# Scoping Opinion – Further Information

Title: Ossian Offshore Wind Farm – Export Cable Corridor

Applicant: Ossian Offshore Wind Farm Ltd

MMO Reference: DCO/2024/00015

Figure 1.1: Sites Proposed to be Screened into the MCZ Assessment for the Ossia Transmission Infrastructure

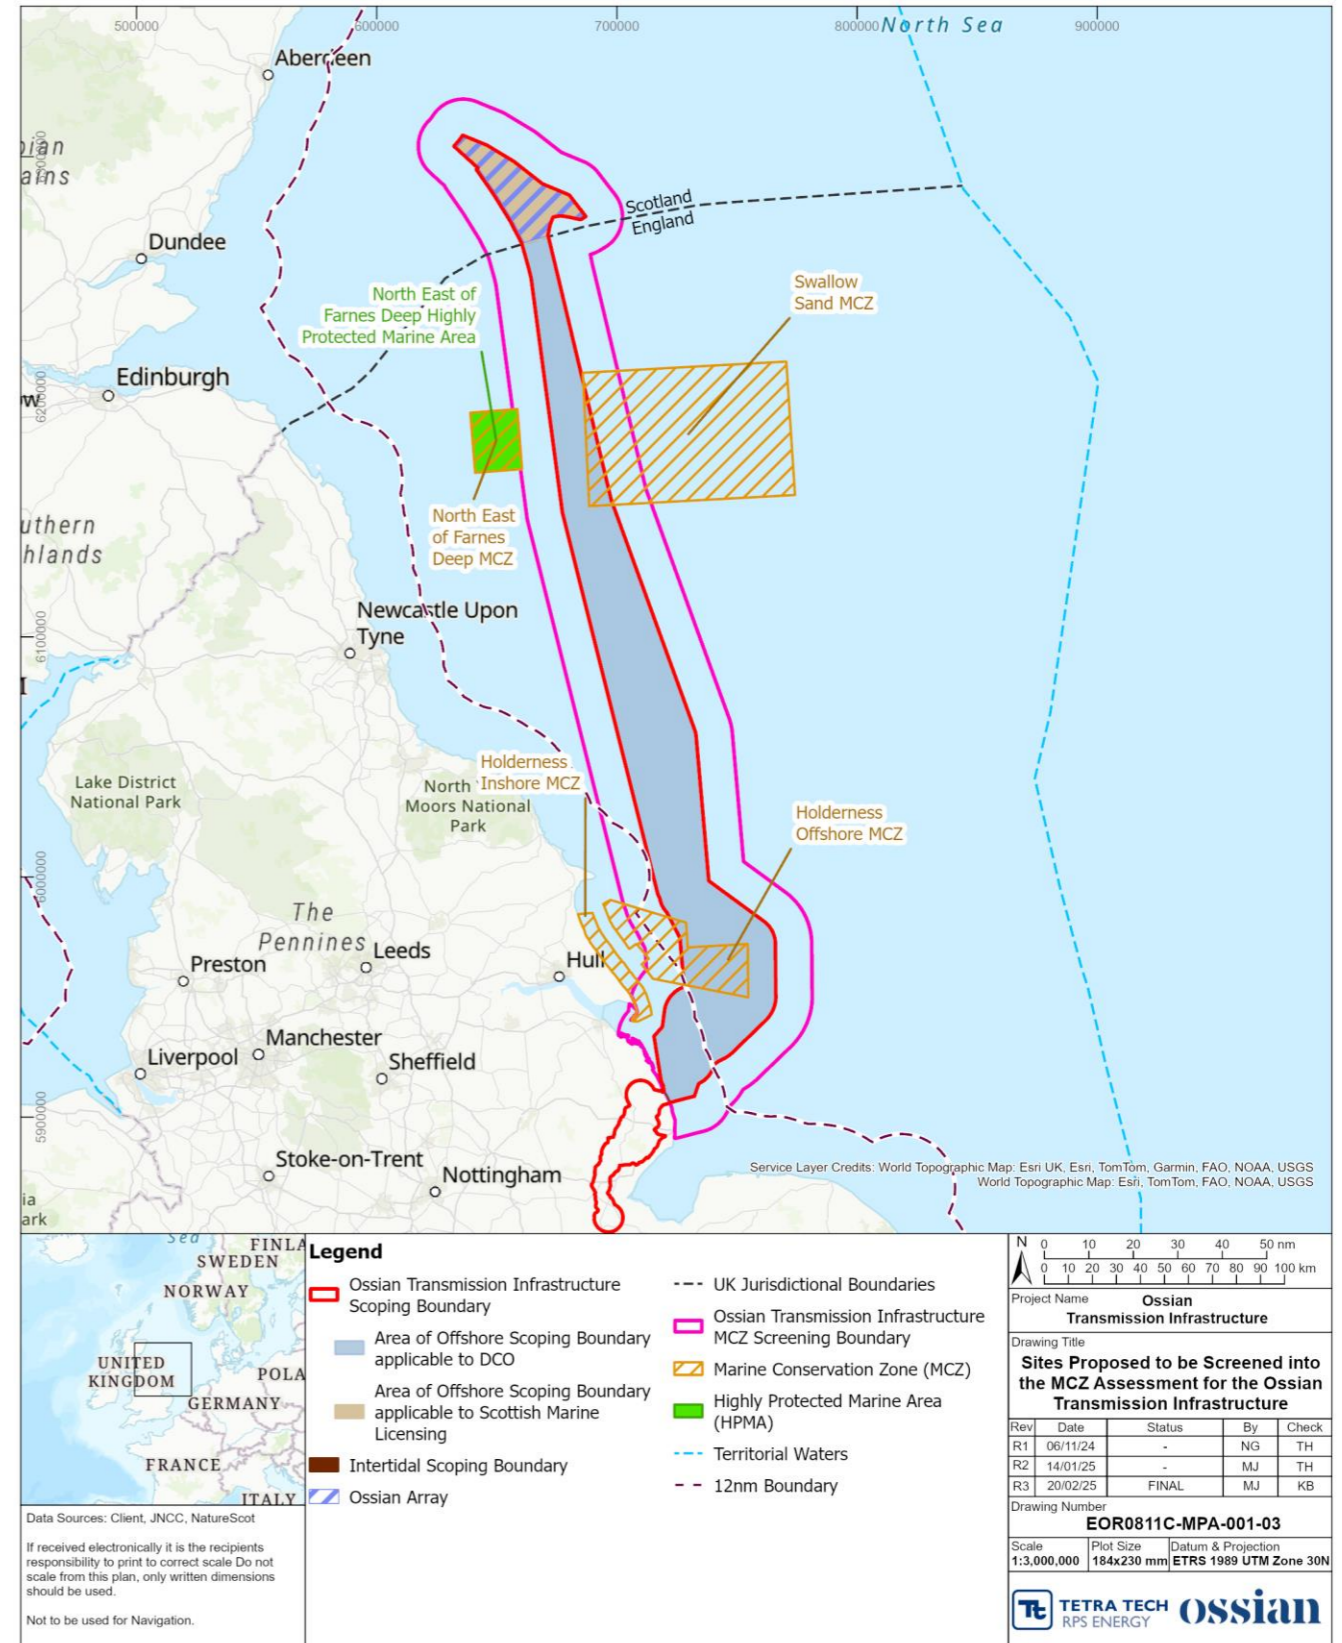
- 6.2 The MMO note that the Holderness Offshore Marine Conservation Zone (MCZ), Swallow Sand MCZ, North East of Farnes Deep Highly Protected Marine Area (HPMA) overlap with the offshore and intertidal scoping boundaries whilst the North East of Farnes Deep MCZ, Humber Estuary Special Area of Conservation (SAC), The Wash and North Norfolk Coast SAC, Inner Dowsing, Race Bank and North Ridge SAC and North Norfolk Coast SAC are all close to the offshore and intertidal scoping boundaries. The MMO defer to the relevant SNCBs with regards to potential impacts and appropriateness of the those that are scoped in and out.

- 6.3 The MMO want to highlight that from the list of designated sites is that the Applicant is applying to overlap with a HPMA, although The MMO defer to Natural England (the SNCB), the conservation advice for HPMA states that “*the physical, biological and chemical ecosystem processes and functions proceed unhindered, so that the site realises its full ecological potential to deliver goods and services, including habitats and species considered important to the long-term storage of carbon, and habitats and species important for flood and erosion protection*”<sup>1</sup>. This therefore implies that the cable may not be suitable to route through a HPMA.
